Submission No.	53
Organisation Name or Name of Submitter	Core Capital (represented by Logical Real Estate Consulting)

RE: RAILWAY (METROLINK-ESTUARY TO CHARLEMONT VIA DUBLIN AIRPORT) ORDER 2022, PROPERTY: 15-18 EARLSFORT TERRACE, DUBLIN 2

Drawing Status	FINAL	
Scale @ A3	1:10,000	DO NOT SCALE
JACOBS No.	32108600	
Client No.		
Drawing No.	ML1-JAI-EIA-ROUT_XX-DR-Y-14009	Rev P02

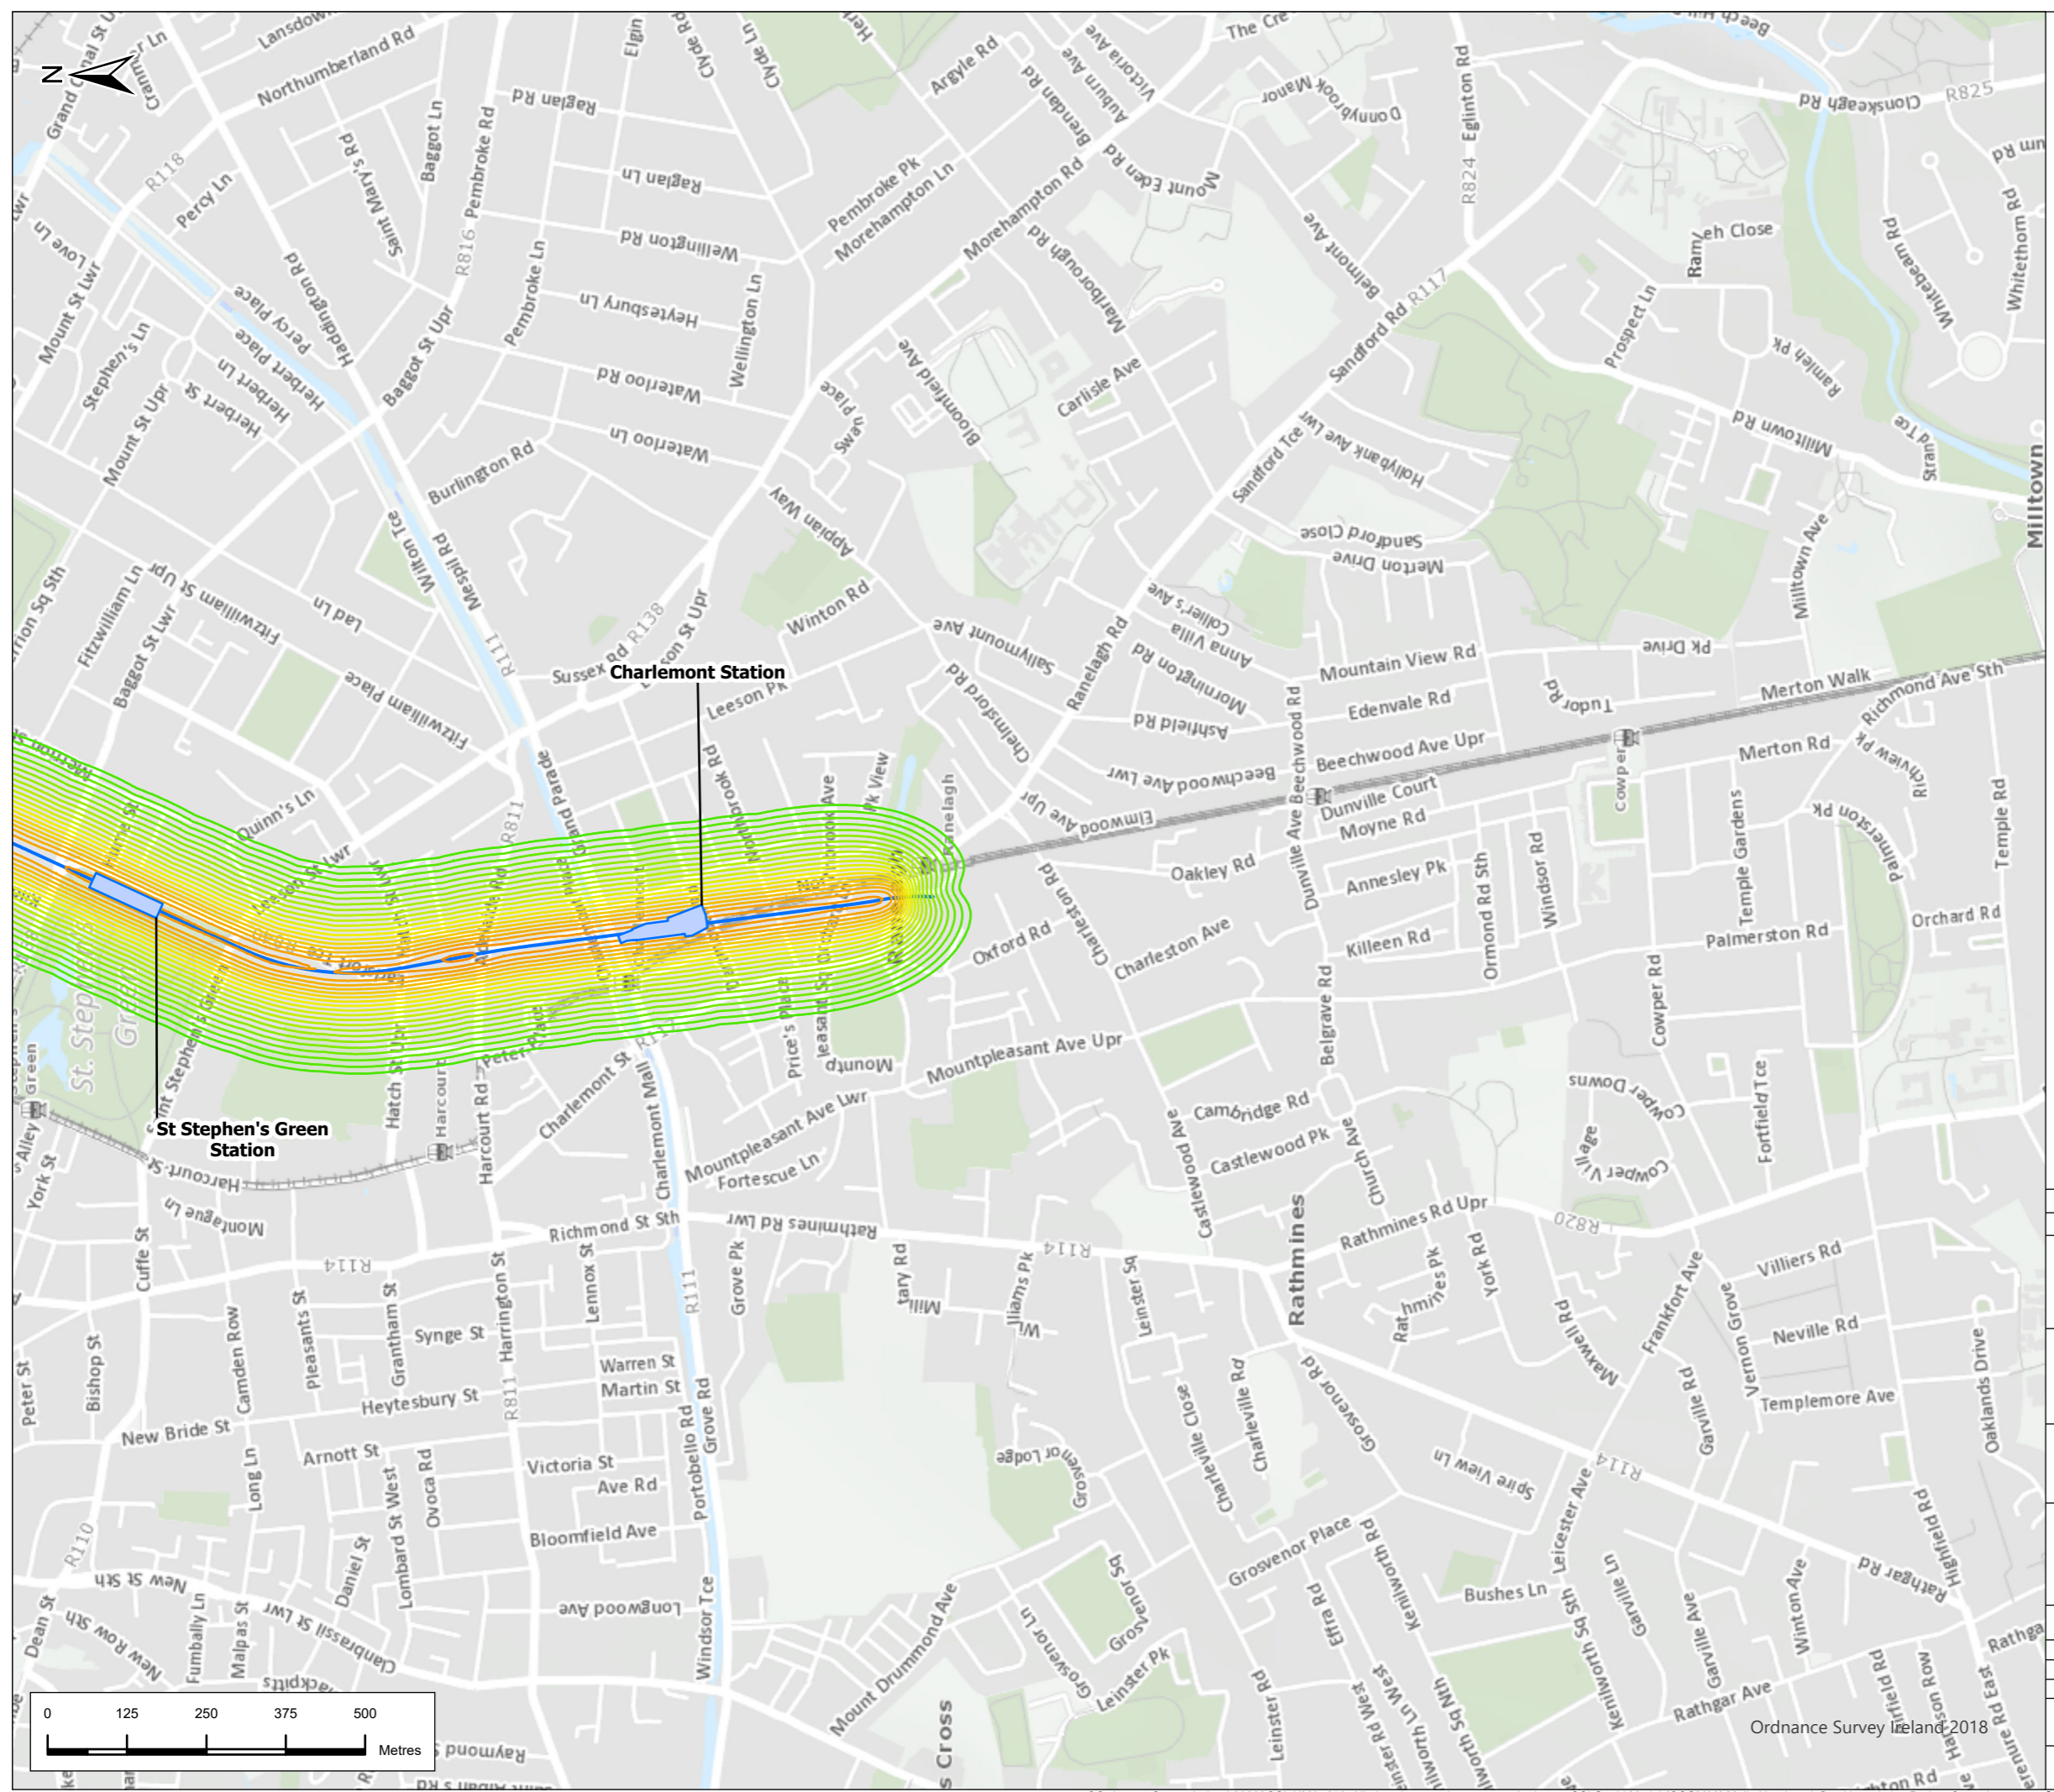
3	Submission 2	2	<p>1. Metrolink has assessed the "Groundborne Noise from Tunnel Boring Machine" and presents its findings on drawing no. ML1-JAI-EIA-ROUT-XX-DR-Y-14009 (a copy is attached to this submission). This drawing indicates MetroLink will generate an additional 50db directly under the location of our client's properties which is unacceptable.</p>	<p>Appendix 14.5 Groundborne Noise and Vibration Blasting Modelling Results presents predicted groundborne noise and vibration levels during the construction and operation phase of the Project for all numbers 15-18 Earlsfort Terrace. Number 15 Earlsfort Terrace is closest to the tunnel alignment, and the prediction of groundborne noise during TBM passage for this building is 50 dB LASmax, which is above the 45 dB LASmax threshold, resulting a significant impact on the buildings operation for the limited duration of circa 2 weeks as the TBM passes. Unfortunately there are no effective methods available to reduce groundborne noise from TBMs at source and therefore the principal mitigation measure is advance consultation and engagement, to inform owners and tenants of the timing of the TBM passing to allow building occupants to prepare for the temporary elevated noise levels. As such, TII will consult with Core Capital in advance of the commencement of construction works.</p>
